Application by Able Humber Ports Ltd for Able Marine Energy Park Material Change 2

The Examining Body's written questions and requests for information (ExQ2)

ExQ2: 13 January 2022

Scale:	Drawn By:	Checked By:	Approved By:
NTS@A1	D Almeida	R Crum	R Crum
Date:	07/12/2020	12/02/2021	12/02/2021
Drawing No:	AME-036-10009	Revision:	C

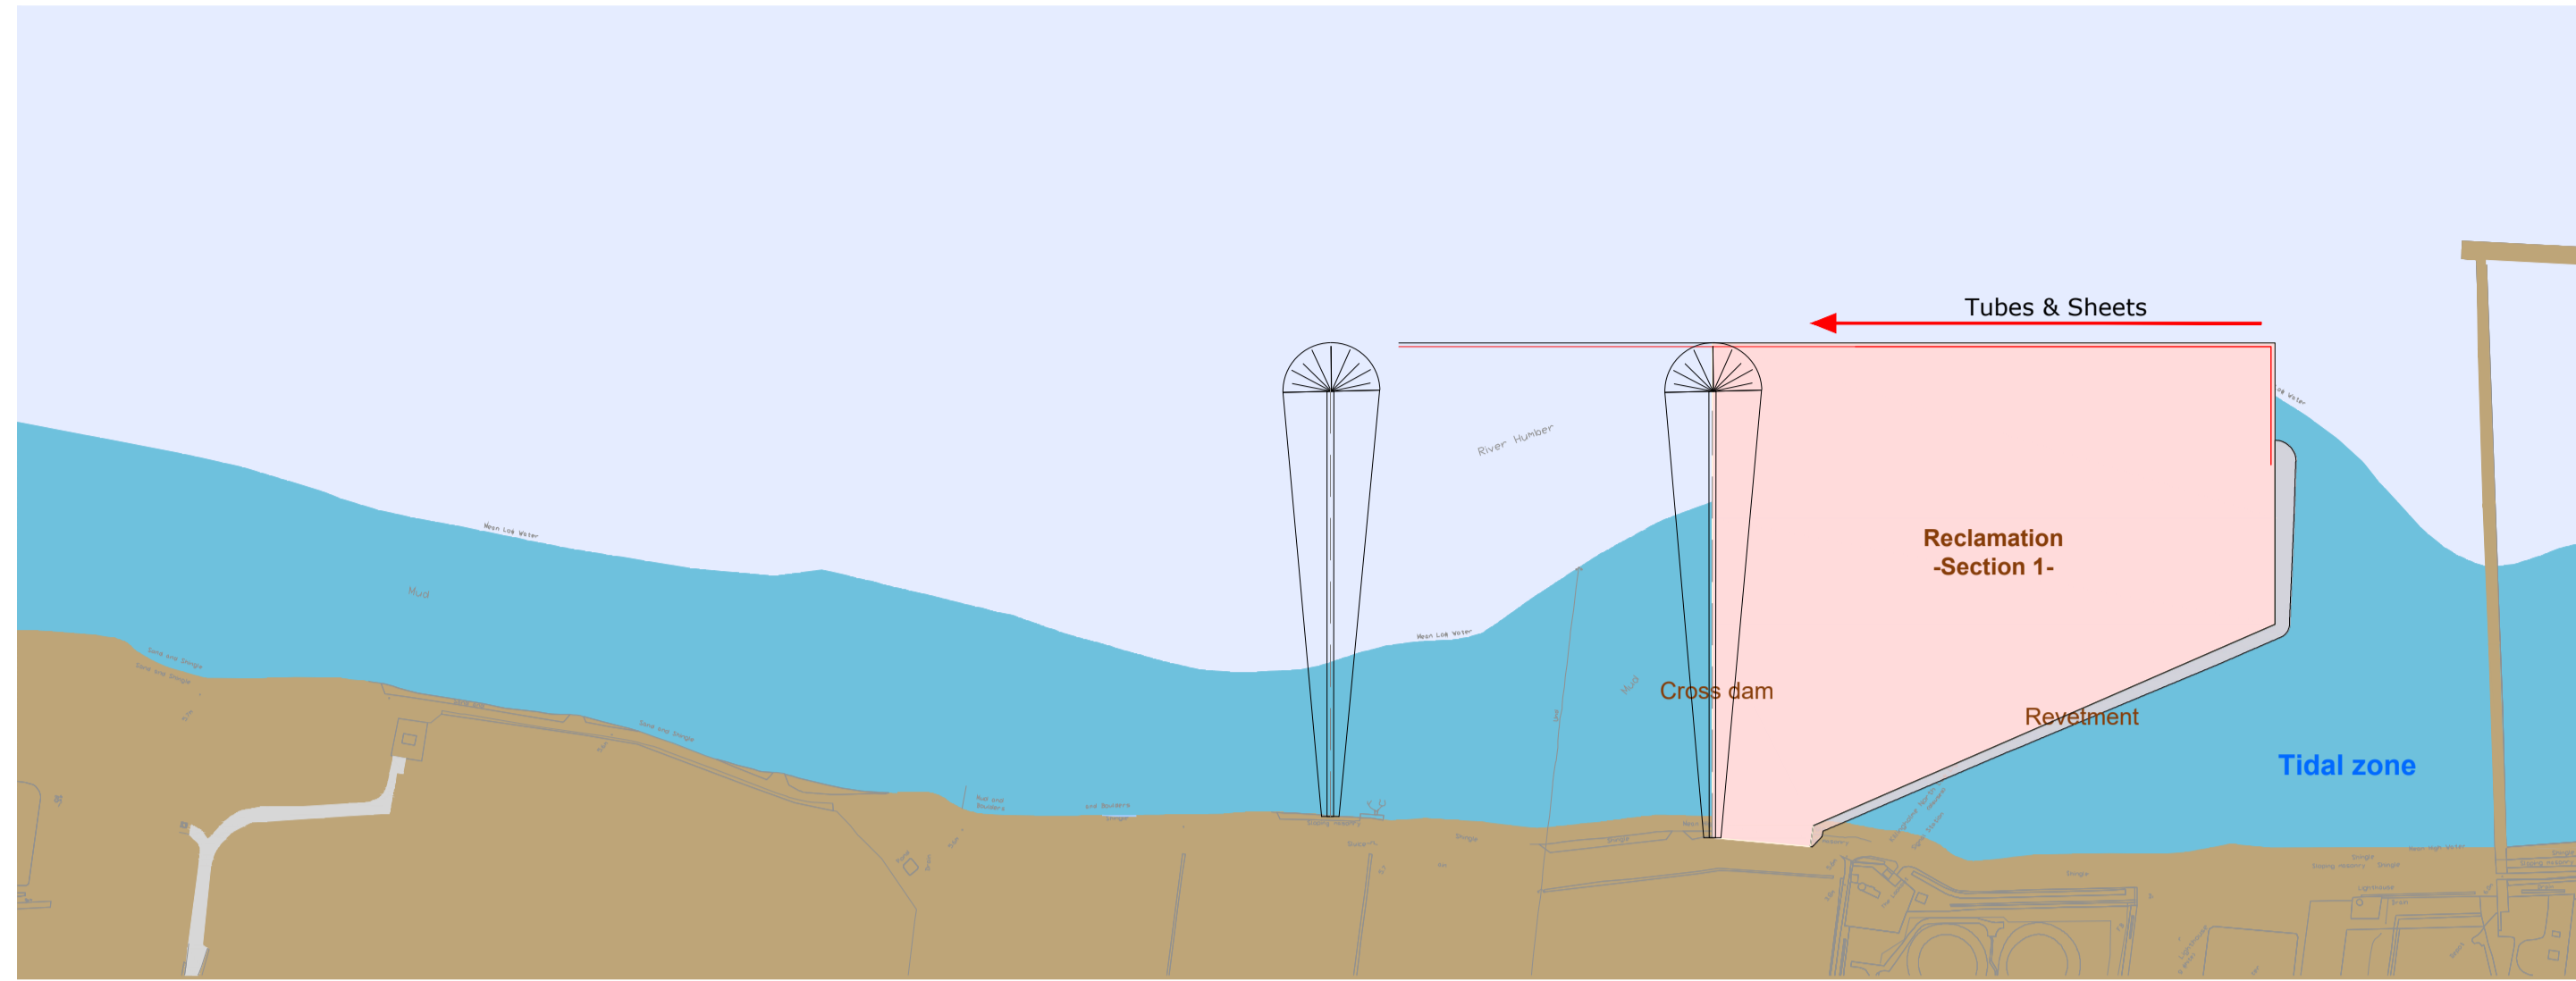
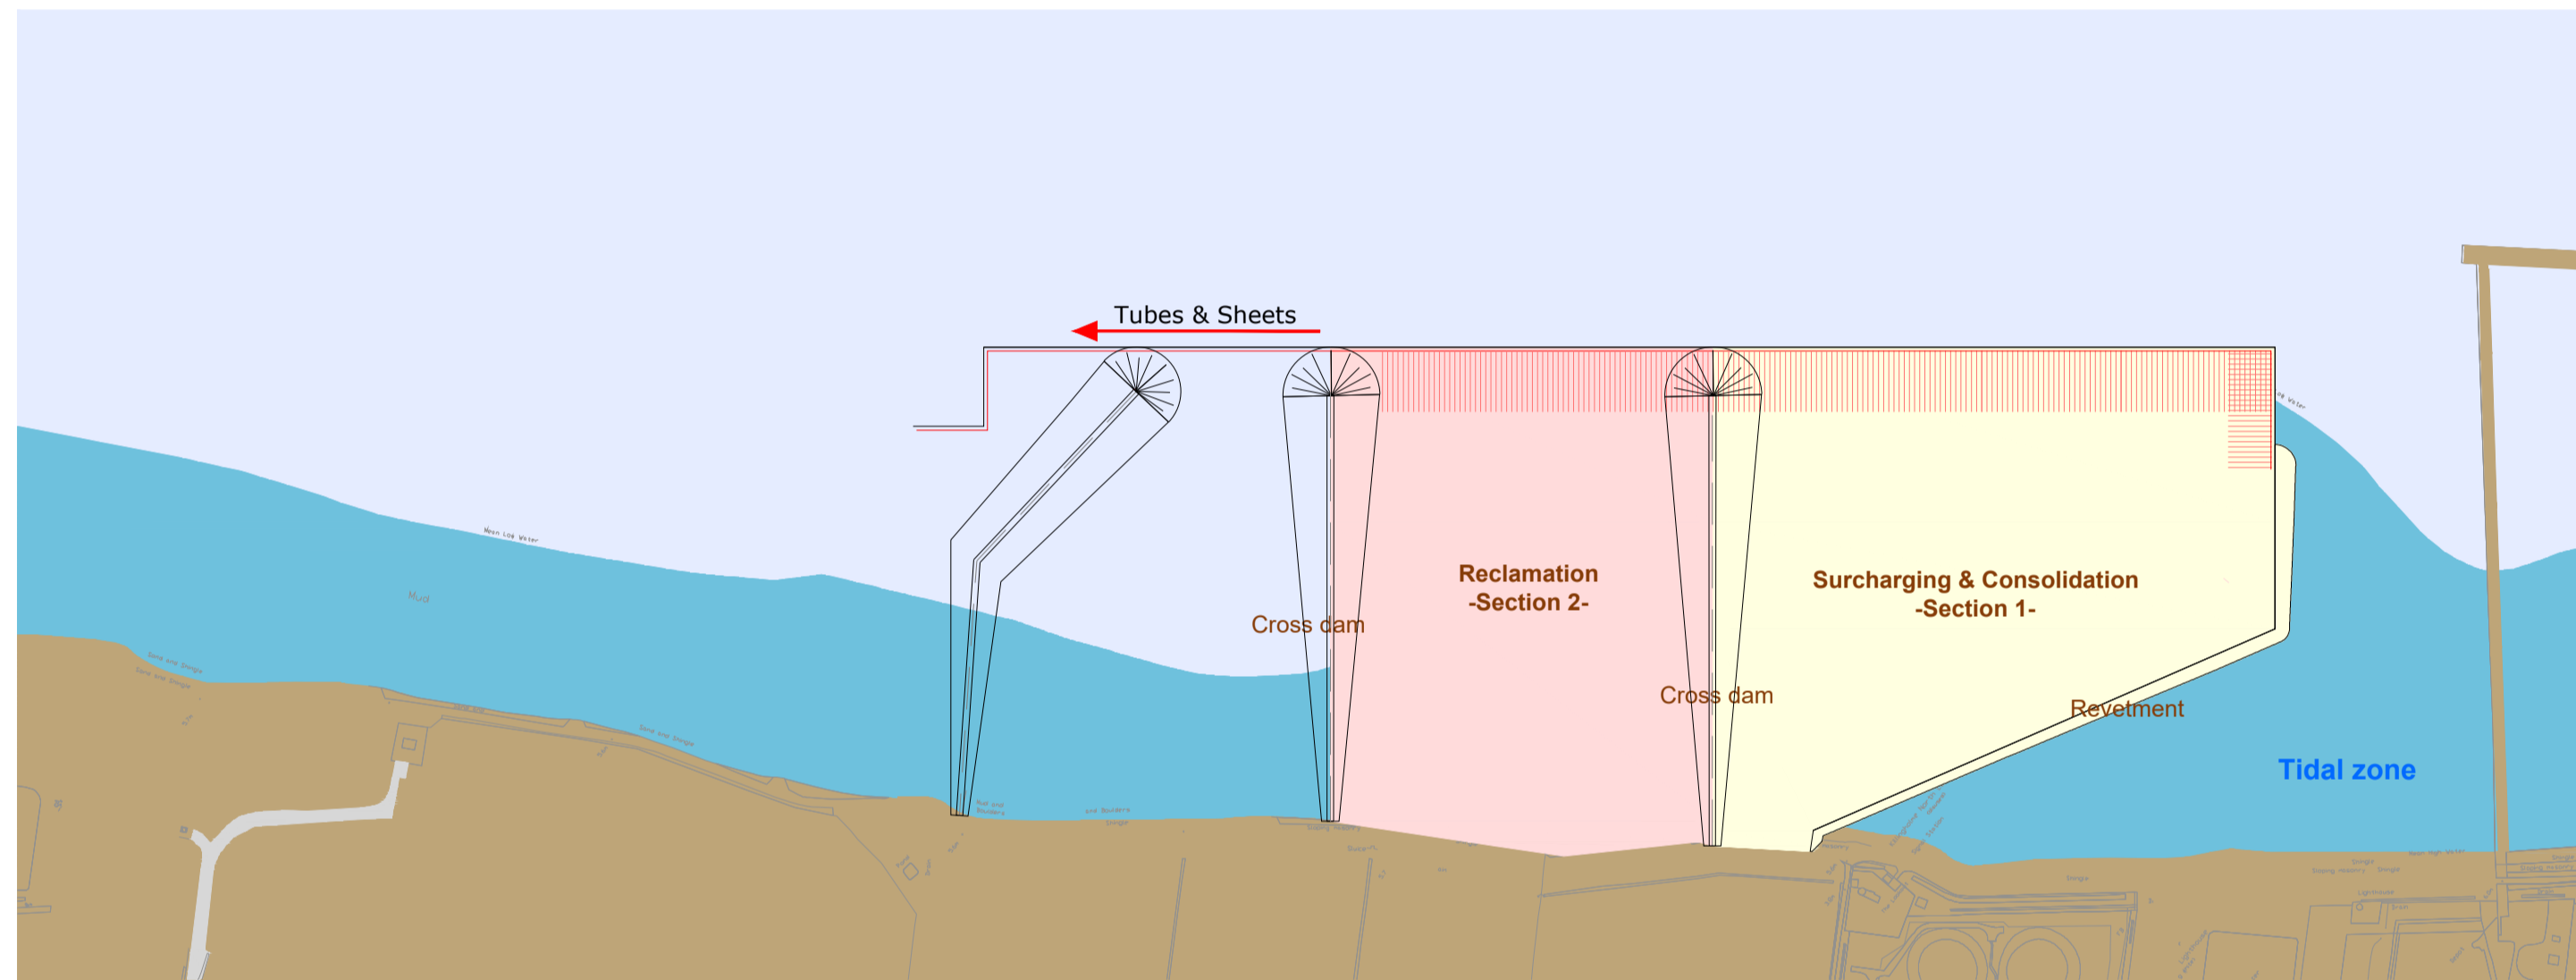
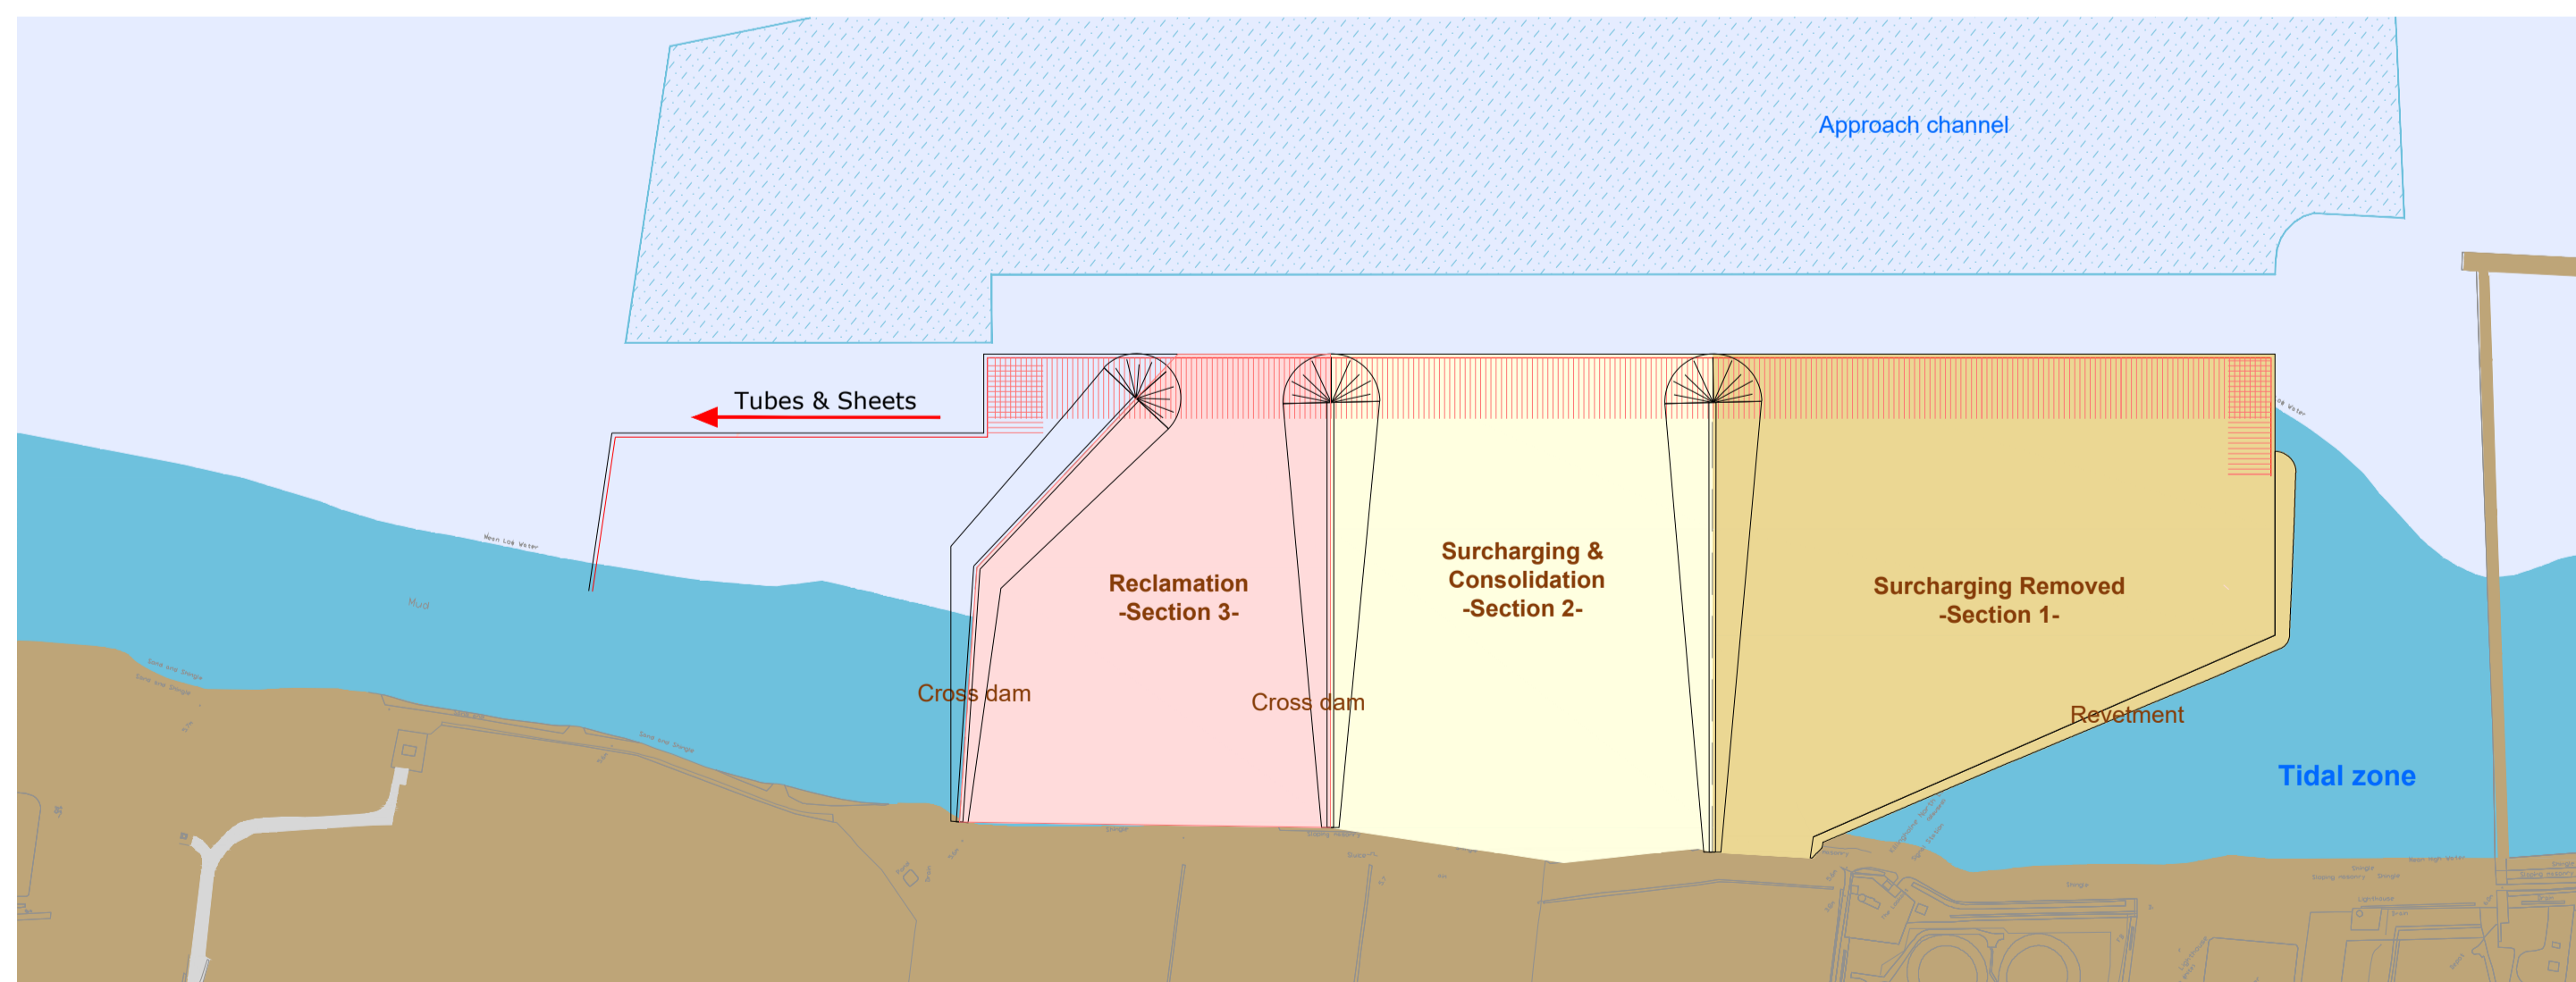
ExQ2	Question to:	Question:
1. General and Cross-topic Questions		
Q1.01	App	<p>Pease supply A3 size copies of drawings AME-036-10009 rev C and AME-036-10010 rev C.</p> <p>These were previously supplied as A1 size copies when A3 size was requested. (The ExB already has AME-036-10011 rev C as it applies to both construction process alternatives).</p>
Q1.02	App	<p>Re: ExQ1: 1.0.2, For clarity please confirm whether I am right to interpret drawing AME-036-10004 rev C as showing two prime alternatives -</p> <p><i>A: Anchor piles plus horizontal steel ties to quay piles</i></p> <p><i>B: Flap anchors plus diagonal steel ties to quay piles</i></p> <p>That each of these prime alternatives could be built without a relieving slab or could have one of two types of relieving slab –</p> <p>1: With vertical supporting piles without a crane rail beam</p> <p>2: With vertical piles and some diagonal piles supporting a crane rail beam</p> <p>There would, therefore (noting the Applicant’s response to ExQ1:1.0.3), be six overall alternatives – A, A1, A2, B, B1, B2.</p>
